November 2, 2017

RE: Meridian Ranch Sketch Plan Amendment 2017_ (SKP-17-001) – Response to 2nd Review

This letter responds to comments received on the second review. Responses to review comments are shown in **RED** below.

EXISTING SKETCH PLAN

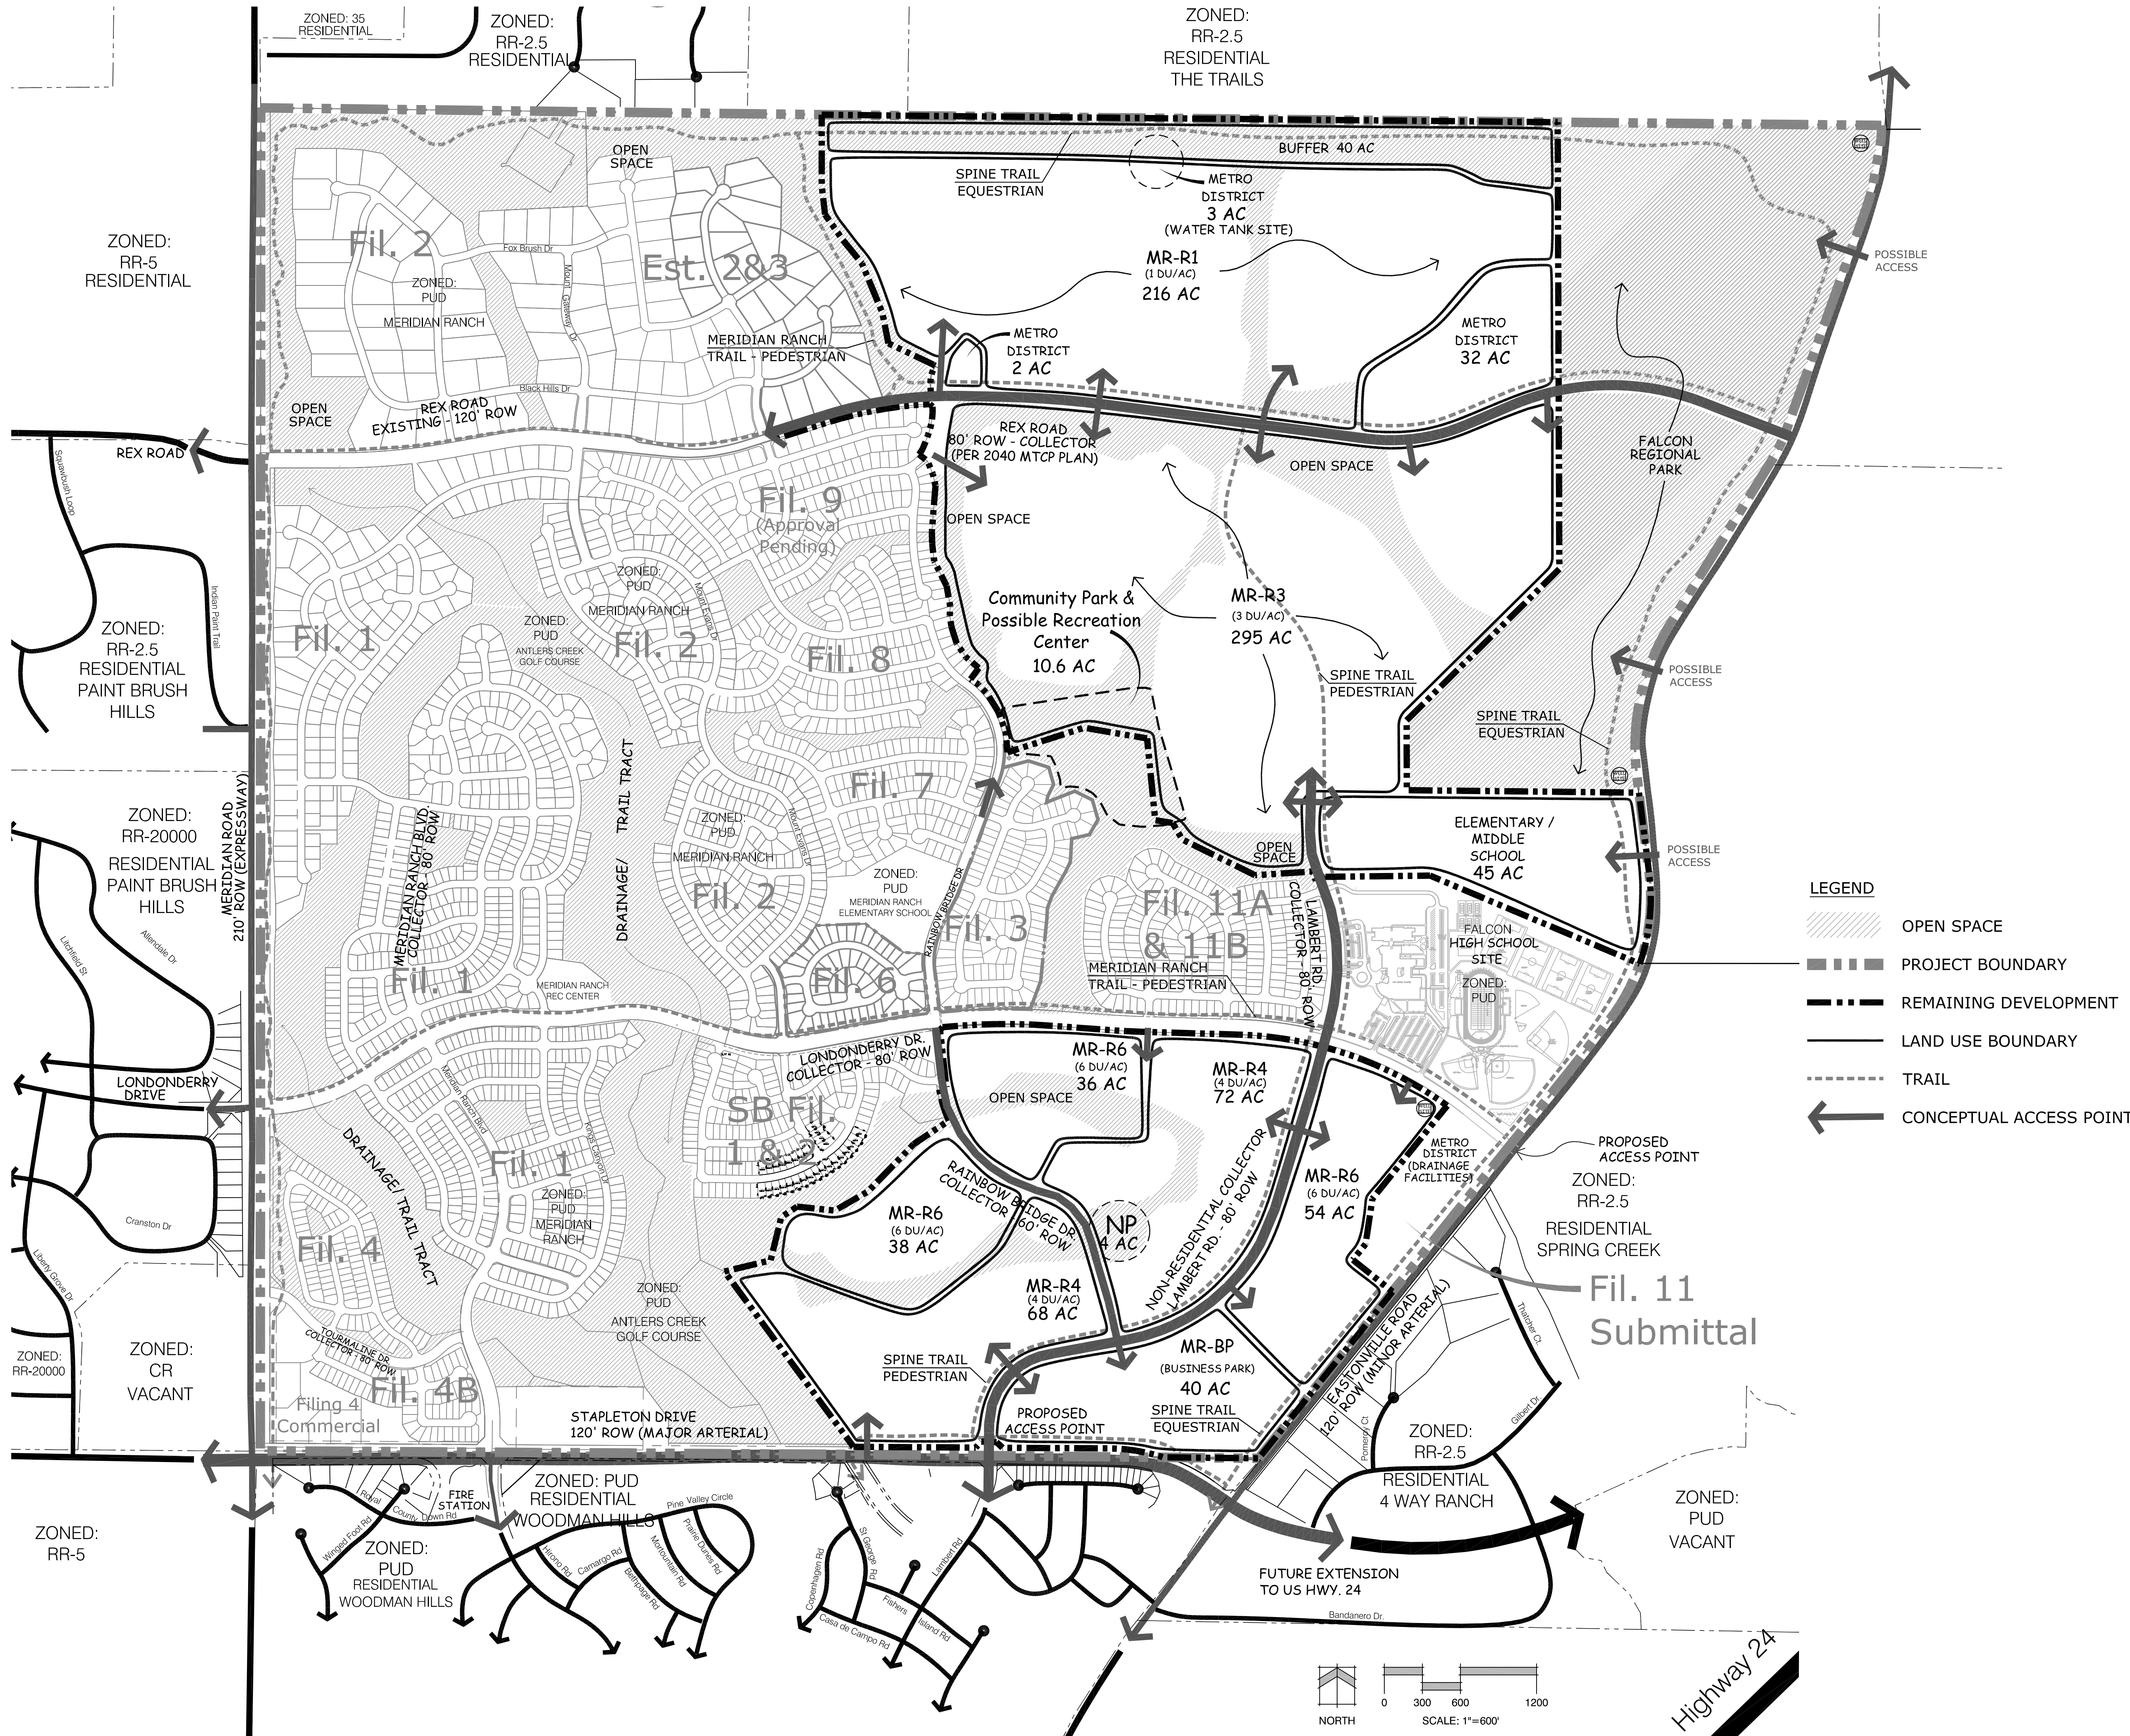
Label sheets 2 and 3 of the sketch plan as existing and as amended. **Amended.**
